From: Frank Ko <Frank.Ko@randwick.nsw.gov.au>
Sent: Wednesday, 25 March 2020 7:24 PM
To: Matthew Rosel
Cc: David Meredith
Subject: FW: 4-18 Doncaster Avenue SSD 9649

This mature Blue Gum (T42) is the one and only tree left within the whole site. It's significant, and fronts directly onto a major roadway/intersection. All other vegetation was cleared to allow for this development, and as they have 4000sqm to work with, it's hard to accept that they now need to construct a massive stormwater pipe in that one part of the site.

The Department asked for Council's comments on the amended tree protection details (for the large Blue Gum) for the SSD application at 4-18 Doncaster Ave.

DWG. TITLE
Landscape Plan
PROJECT
4 - 18 Doncaster Avenue, Kensington

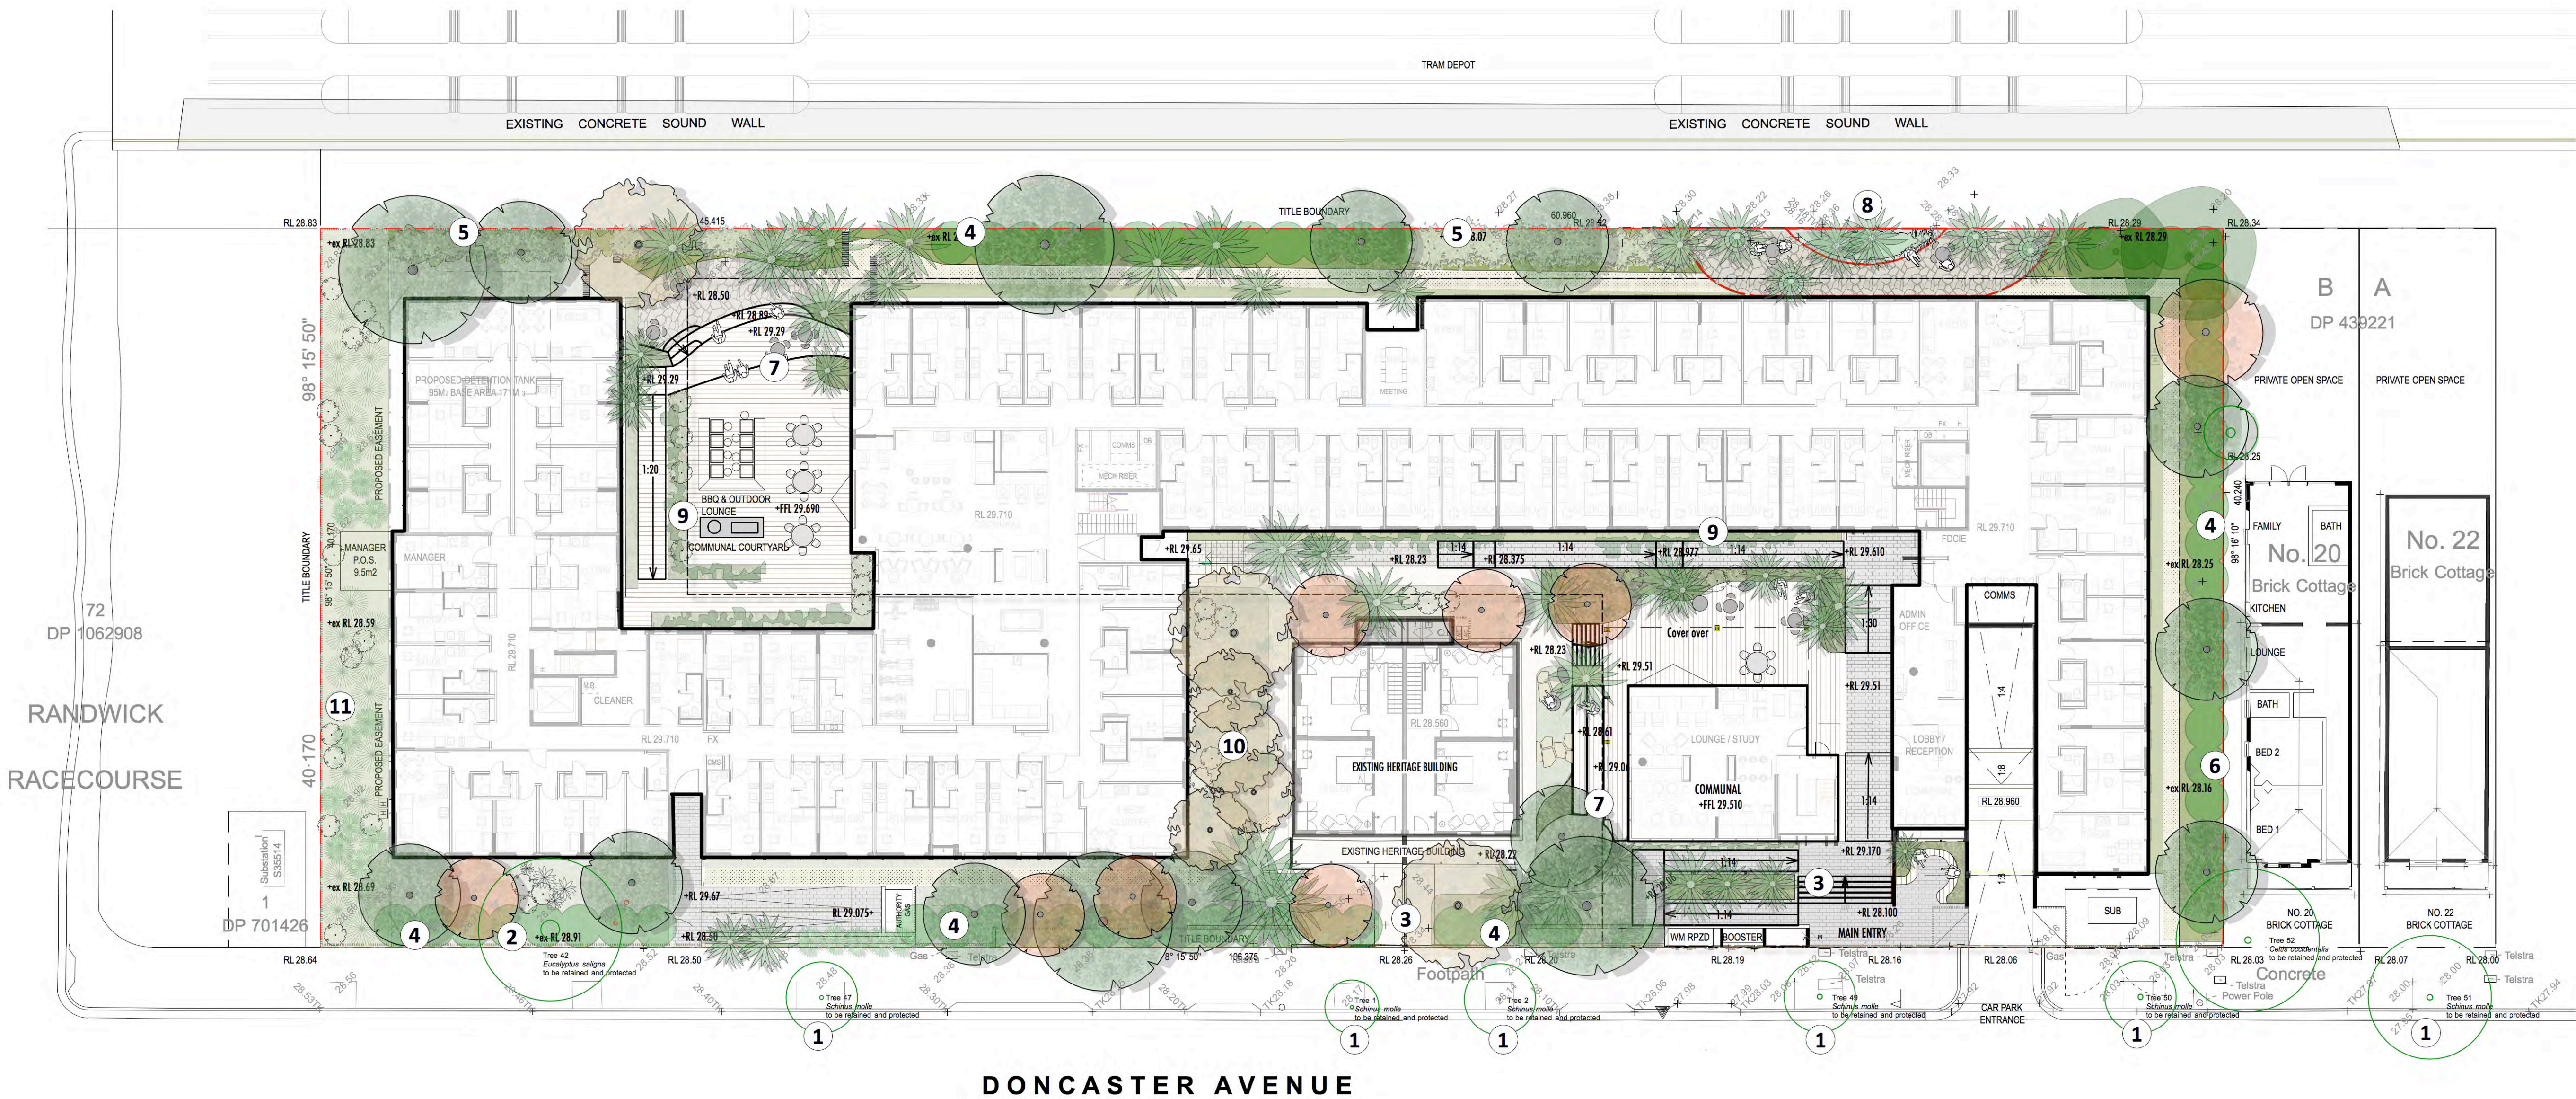
While the documents refer to a 3 metre setback from its base, the Project Arborist has indicated to me in a phone discussion earlier today that following consultation with himself that resulted in a slight re-design, the offset will in fact be 6m. I've requested formal confirmation of this in terms of revised/stamped plans etc, if that's what I'll be relying on.

Regardless, for a 1.8m diameter concrete pipe, excavations will be in the order of 4m x 4m, which will encroach its TPZ but fall just outside its SRZ.

I find it hard to believe that a more suitable alternative solution can't be found, as compromising the tree or requiring its removal to allow for this pipe is not an acceptable outcome in terms of site planning or environmental amenity. Root pruning here could also be dangerous given its size, location adjacent a busy public domain (vehicles and pedestrians) and its existing lean/bias towards the road.

- The supplied Sydney Water Plan (case no 175826SW) shows that a 1800mm diameter reinforced concrete pipe will be located 6m to its west (over the footpath and road), and 8-9m to the bend to its north and along the northern site boundary;

- This would place the works outside its 3.8m SRZ, but within its 11m TPZ, with these cumulative impacts needing to be calculated as a % by the Arborist to determine overall encroachment;

- Excavations will be by machinery, up to 4m in depth and 4m in width;
- A Work Method Statement should be submitted for the approval of the Project Arborist, showing that there will be no over-excavation that would result in works being performed closer to the tree than the final location of the pipe, and will involve the use of shoring systems and similar tree sensitive construction methods;

- Tree exhibits an existing bias to the west, directly over the footpath and roadway, so canopy reduction to balance the tree needs to be performed by selective pruning of the 2 x lowest, middle order leaders to the west, to AS4373-2007;

- AQF Level V Project Arborist needs to be appointed to be present on-site to ensure adequate protection measures;
- Any root pruning will require on-site consultation with Council's Officer (9093-6613).
